## WEST SUSSEX COUNTY COUNCIL CONSULTATION

<b>TO:</b>	Arun District Council FAO:Harry Chalk
<b>FROM:</b>	WSSC – Highways Authority
<b>DATE:</b>	3 March 2025
<b>LOCATION:</b>	Kivesborough Littlehampton Road Worthing BN12 6PN
<b>SUBJECT:</b>	FG/15/25/PL Subdivision of existing curtilage and erection of 3 No 3-bedroom dwellings (self build), retention of existing access and provision of landscaping (resubmission following FG/49/24/PL). This application affects a Public Right of Way and is in CIL Zone 4 and is CIL.
<b>DATE OF SITE VISIT:</b>	n/a
<b>RECOMMENDATION:</b>	No Objection

Project		
Kivesborough		
Fire Appliance SPA OUT		
Drawn	Date:	Scale (at A3)
BTM	17/10/2023	1:200
Dwg no.	Revision No.	
KB/SR/5004	A

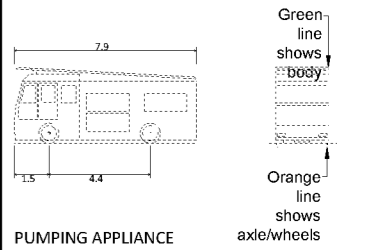
SPA diagrams for a small refuse lorry and fire appliance have been submitted and confirm that these two vehicles can enter turn and exit the site in forward gear. As the site is accessible from the private car parking area of Ferring Nurseries access through the car park is not within the public highway and the private access road to reach these properties will need to be a minimum of 3.1m kerb edge to kerb edge for a fire appliance to gain access.
